WEST SUSSEX COUNTY COUNCIL CONSULTATION

TO:	Arun District Council FAO: Patrick Arthurs/David Easton
FROM:	WSSC - Highway Authority
DATE:	23 rd June 2022
LOCATION:	Barnham, Eastergate, Westergate BEW Parcel SC1 Barnham
SUBJECT:	BN/11/22/OUT Outline application with all matters reserved (except for the A29 Realignment) for the demolition of existing structures and mixed use development to provide residential dwellings (Use Class C3), Care Home/Senior Living Accommodation (Use Class E/F2/Sui Generis), a Primary School plus open space, landscaping, drainage and all other associated ancillary works; and realignment of the A29 and early connection to existing A29 including construction of a new road carriageway, junctions and associated infrastructure. This application also lies within the parish of Aldingbourne, affects the setting of listed buildings, affects the character & appearance of the Eastergate Church Lane Conservation Area and affects a Public Right of Way. This application is the subject of an Environmental Statement. An amendment received

This is the third WSSC Highways (CHA) response to the above planning application for outline application with all matters reserved (exc

Drawing Title
**INITIAL BRIDGE OPTIONS
MULTI SPAN**

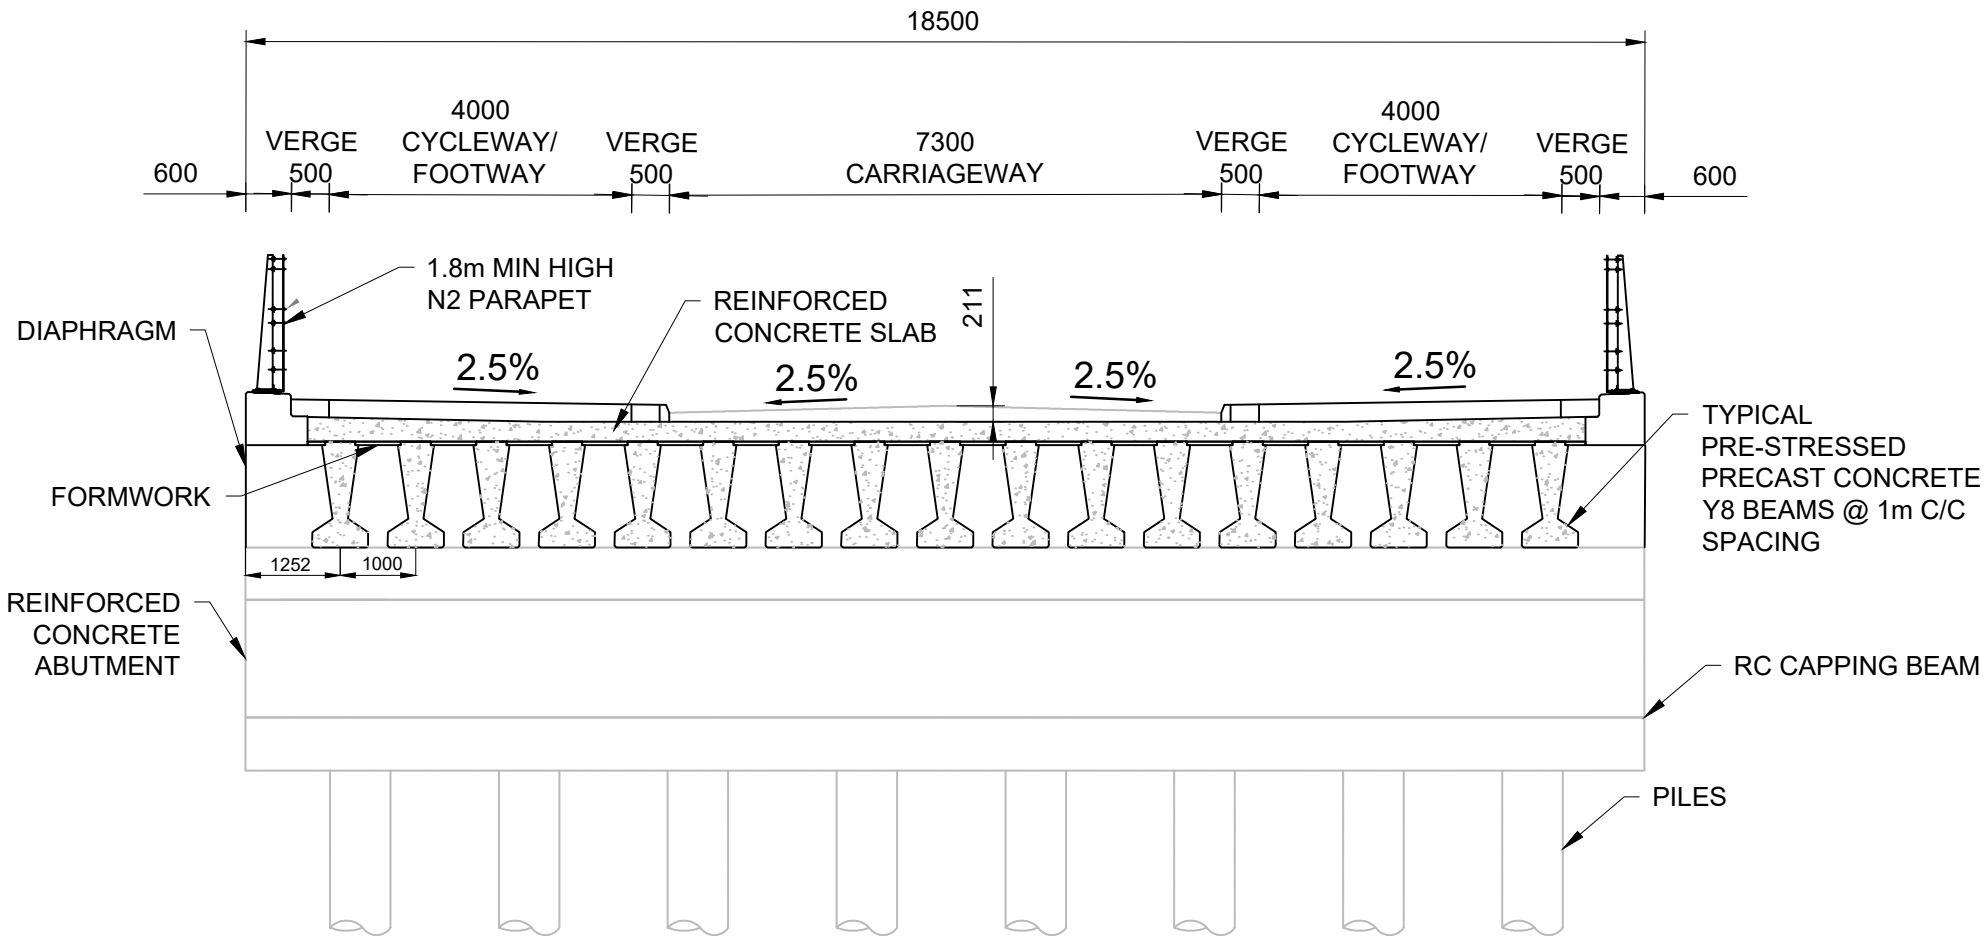
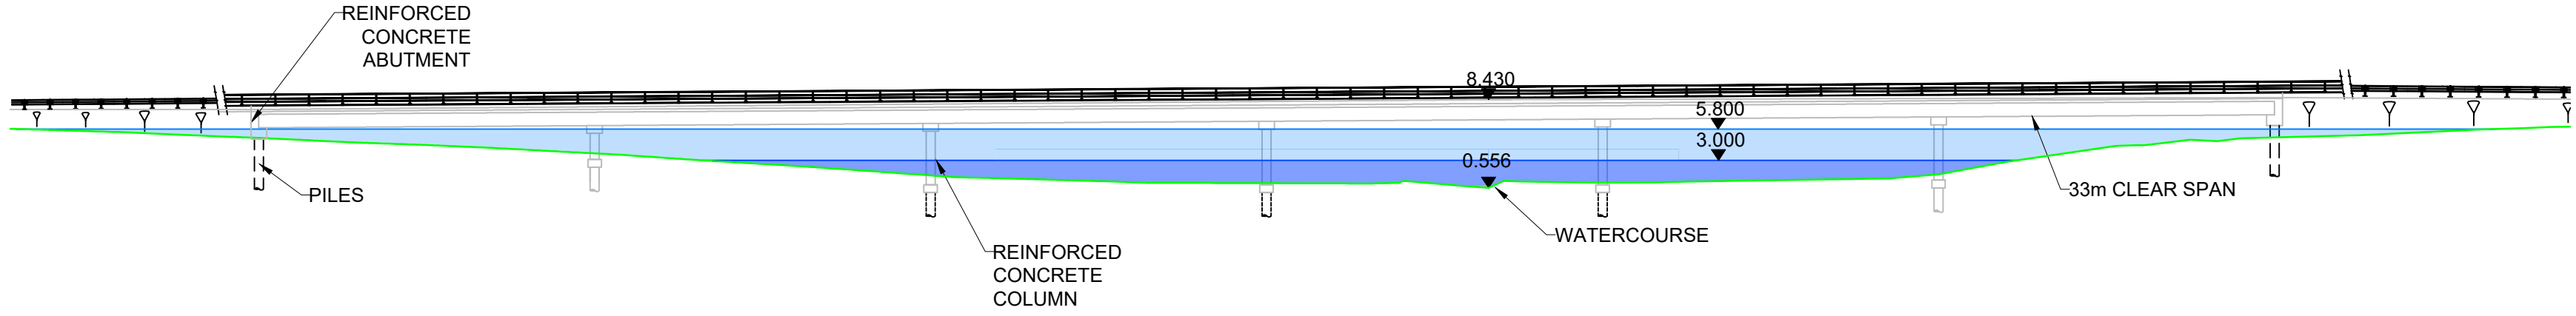
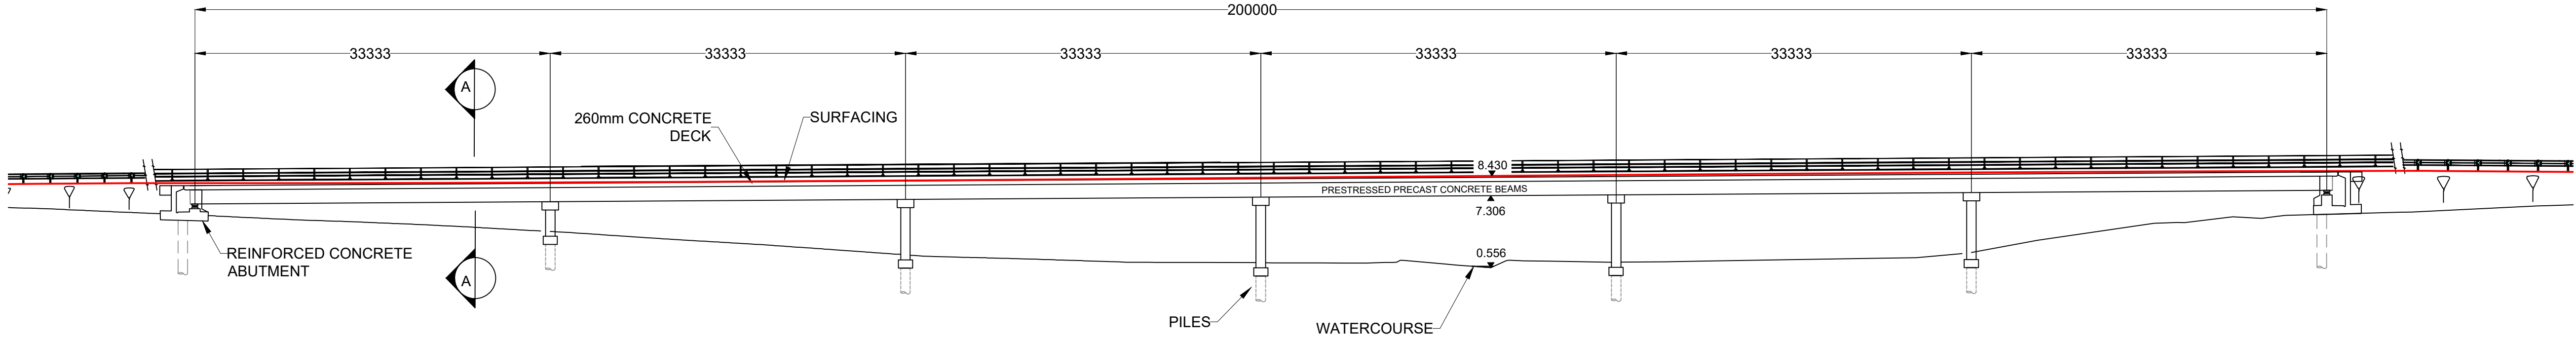
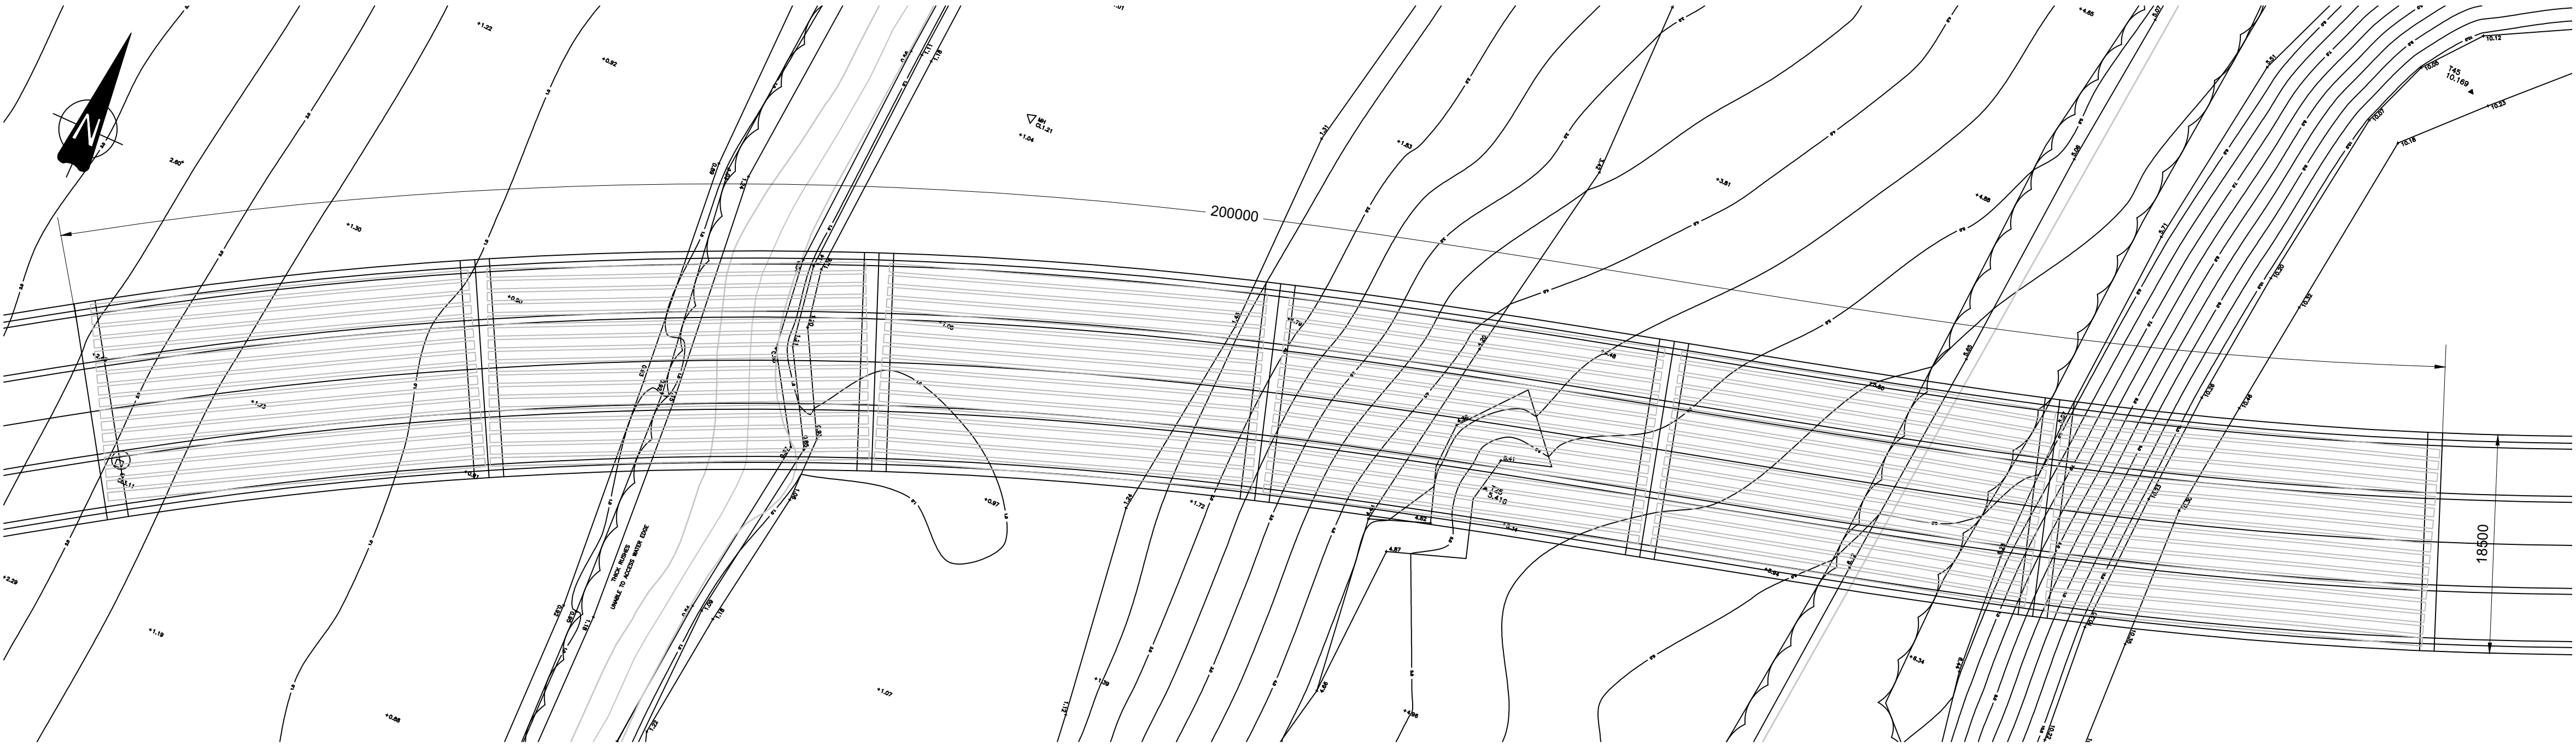
The Technical Note (TN) is geared towards either a) a 200m long multi-span viaduct, or b) a 30m single span structure. The reason for the massive variance is as stated in the front of the report, see screen grab below.

Given as much, the vast majority of the content of the TN is of limited use as it only discusses 1 No. viable option. The TN should have addressed various single span options (e.g. weathering steel, U or W beams similar to the Options Report for the rail bridge). As a result, the drawing is certainly of interest but also of limited value (in the context of 'options'). Perhaps the rife bridge could basically be a repeat of the rail bridge (the widths should be identical and the spans are very similar)?

WSCC structure ref: 1780 – item 1 – A copy of the revised report is requested at the earliest opportunity. Decisions made within will set the scene for the format of the structure so early sight of this is important to ensure that all parties are in agreement before the design moves towards AIP (presuming planning permission is granted).

However, recent discussions with the Environment Agency have reduced to the flood level to 2.2m AOD at point of crossing. ~~As a result, the structure clearances can be reduced and therefore the multi span bridge is no longer a viable option. For information purposes, the multi span structure proposal is included within the report.~~

Technical Note updated as required.
